Subject: M/5/11/NMA - Installation of two roof lights on the rear elevation and three roof lights on the porch roof on the front elevation - Amendment to approved planning permission M/6/09.

APPROVED UNDER m/6/09

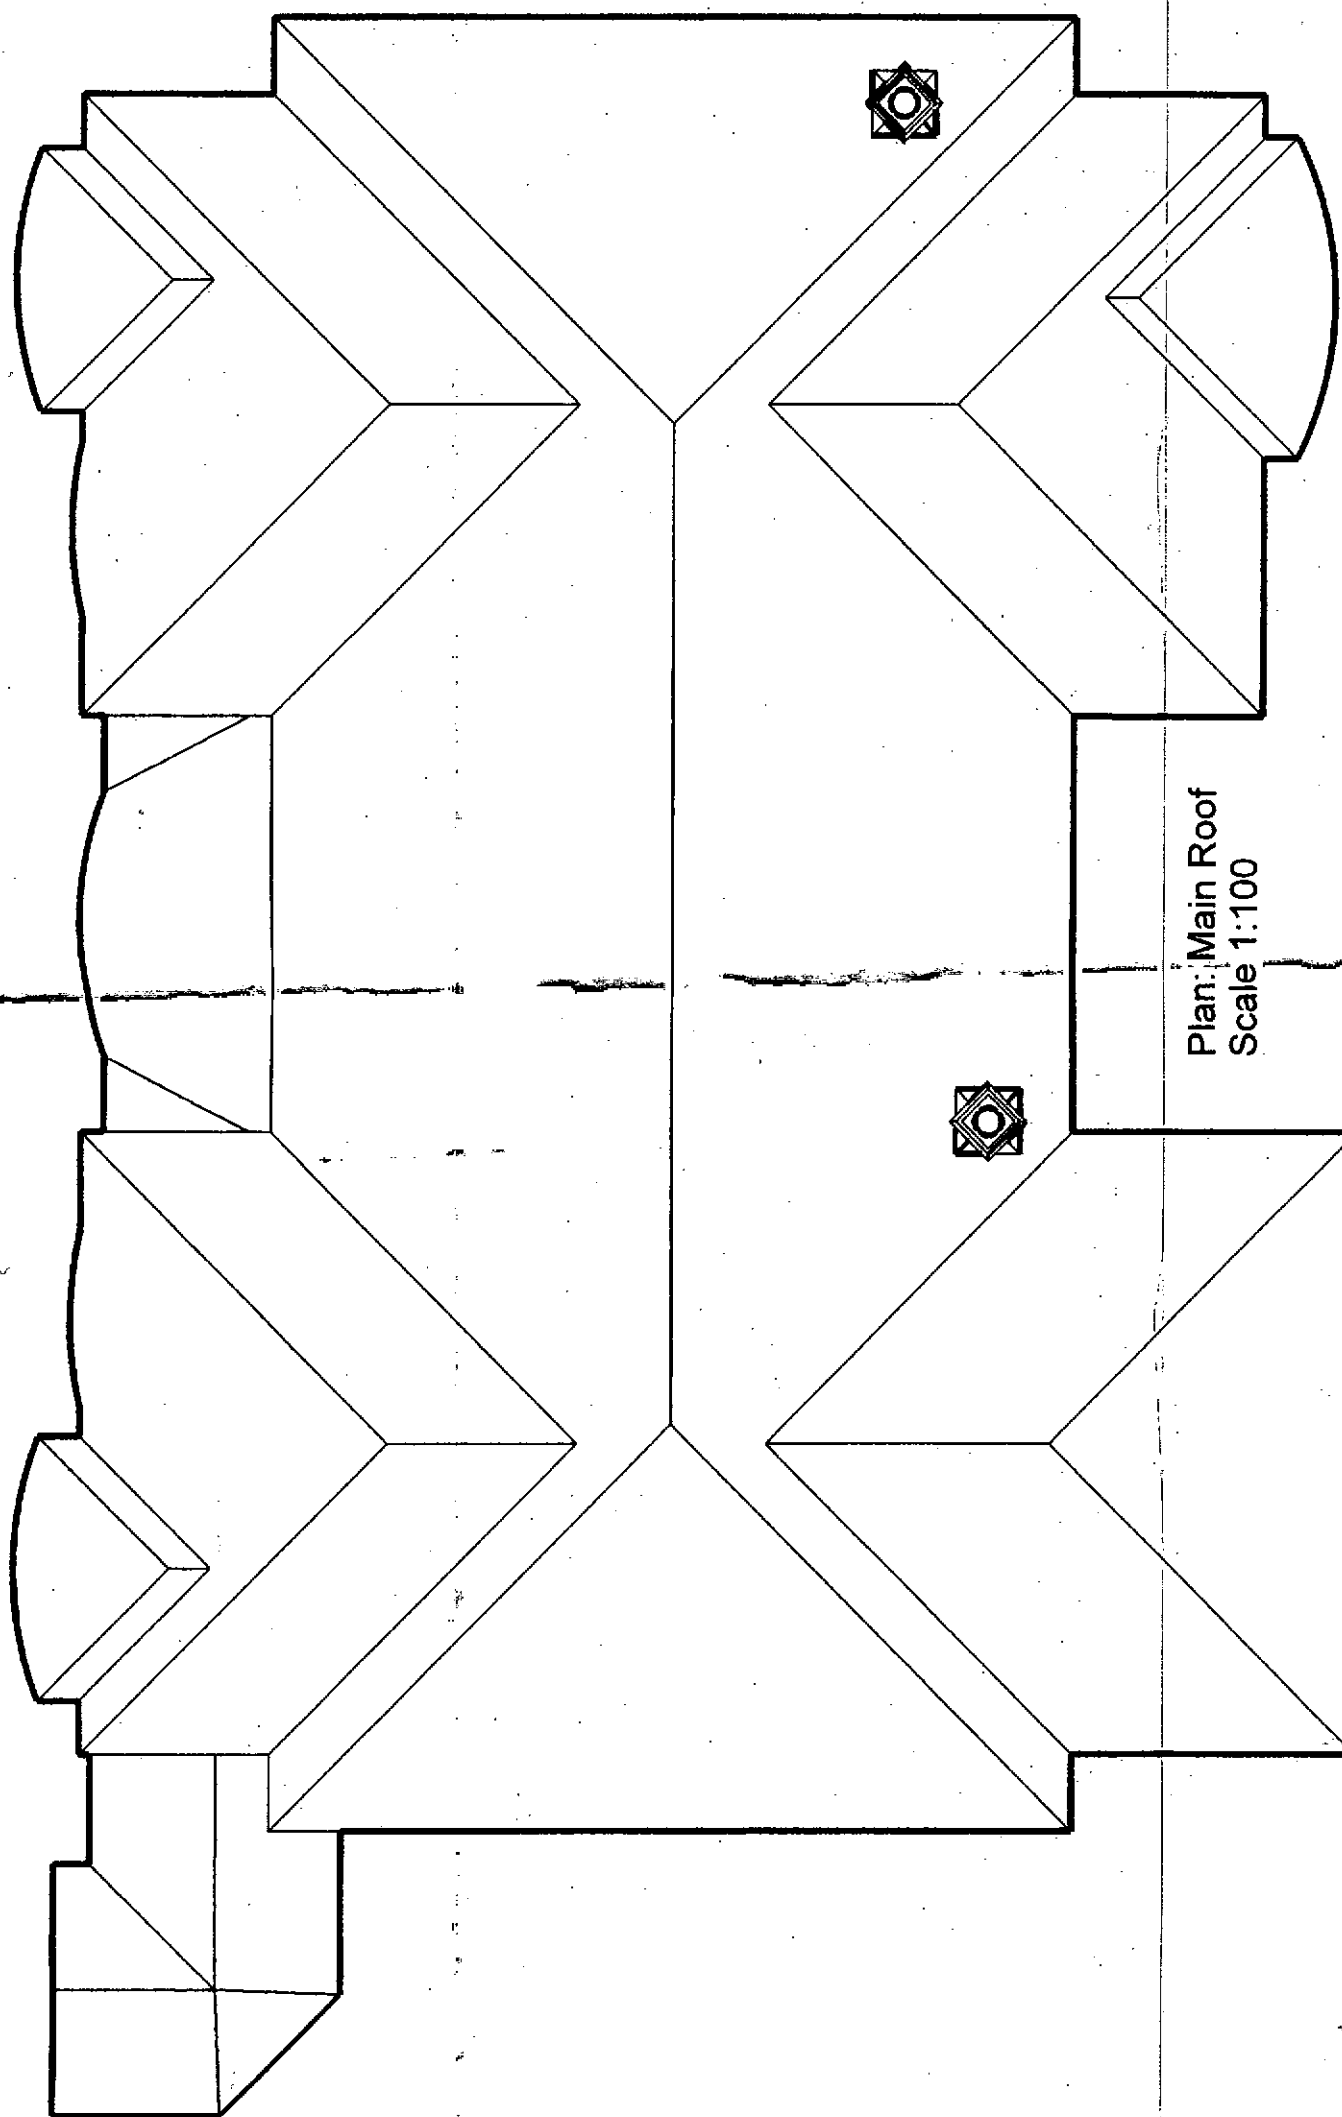
The rear elevation as approved under M/6/09 Drg No GRJ64SW 201 shows a chimney, has this been deleted.

The front porch as approved under M/6/09 Drg No GRJ64SW 201 differs from the plan submitted in design and now shows a substantial roof. To assess whether this can be accepted as a non material amendment I need to see a floor plan and side elevation showing the amended design.
